Reference: JH / 12690 – 10.02.2020

LLFA Objection – Hertfordshire

Reference: RE: 6/2019/1411/MAJ

Drawing Title
**Workshop A and B and East Showrooms
 Roof Plans**

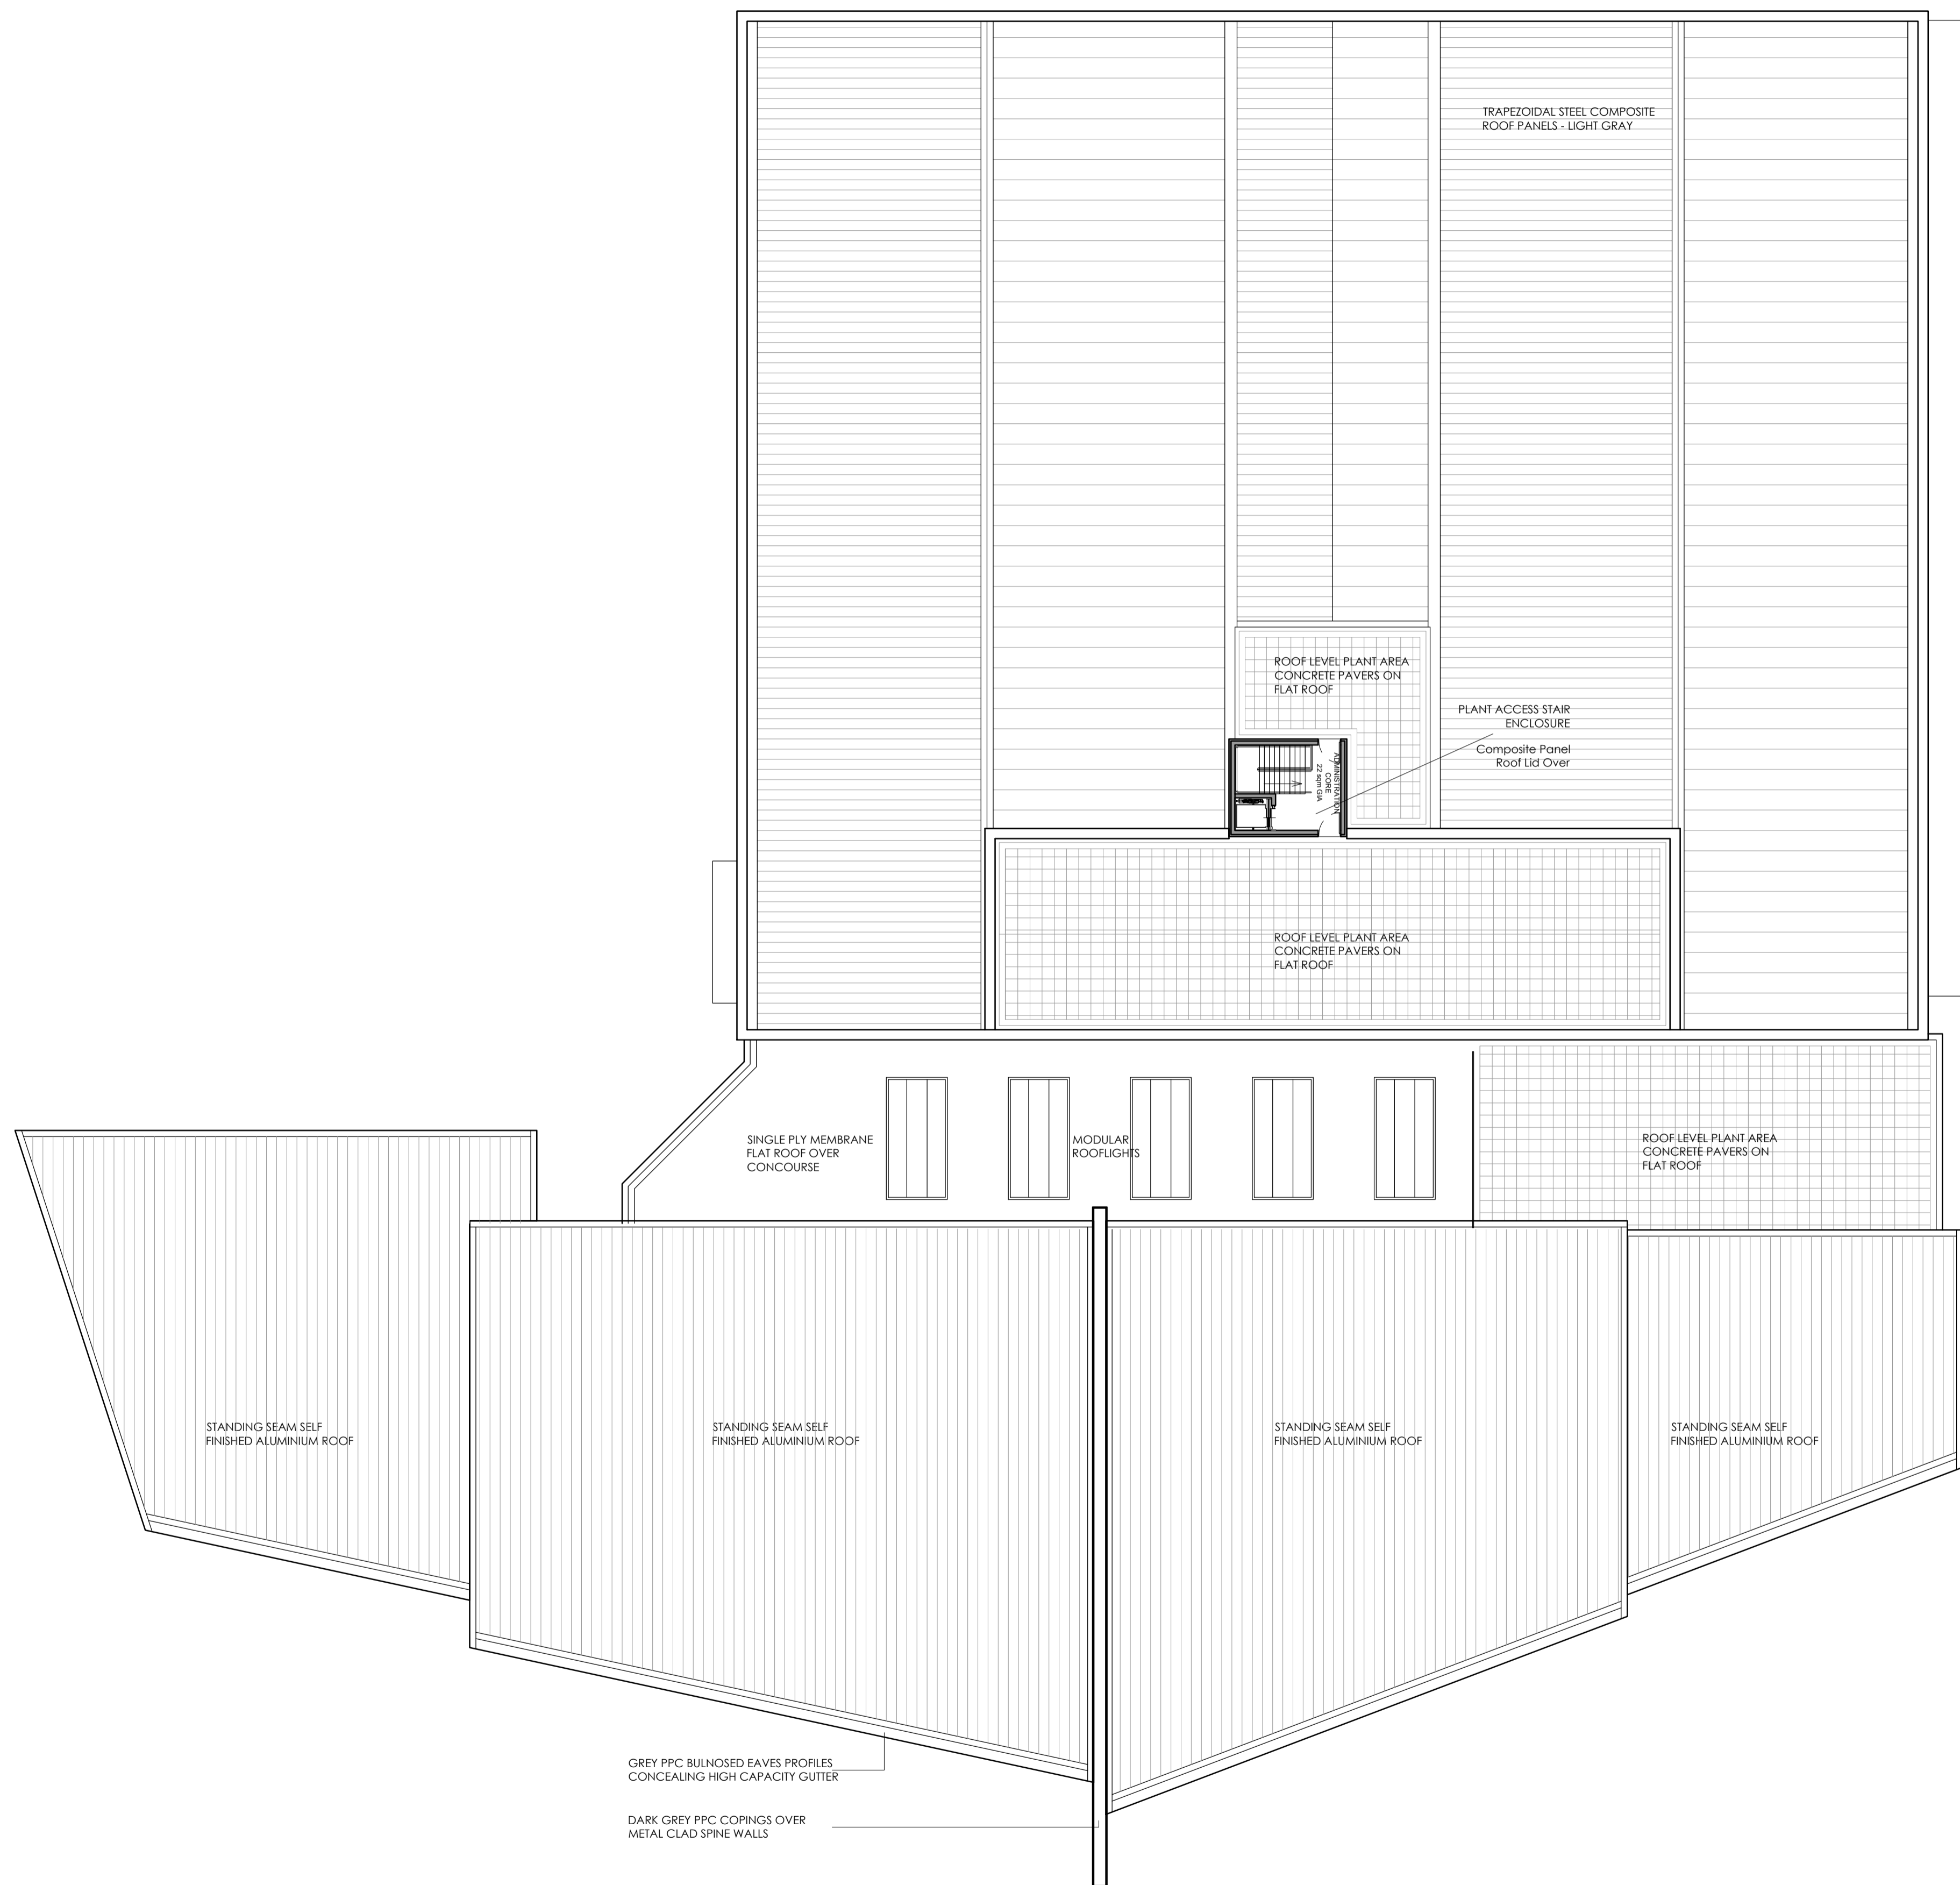
1. *An updated drainage strategy to include reduced discharge rate*
2. *Evidence that if the applicant is proposing to discharge to the local sewer network that they have confirmation from the relevant water company that they have the capacity to take the proposed volumes and runoff rates.*
3. *Further details on SuDS management stages provided within the drainage strategy.*
4. *Details of any required maintenance of any SuDS features and structures and who will be adopting these features for the lifetime of the development*

Green roofs: Space is limited due to the need to provide for plant and vehicle display areas on the roof. Also, cost to the structure roofs can be considerable. Therefore, green roofs have been disregarded.
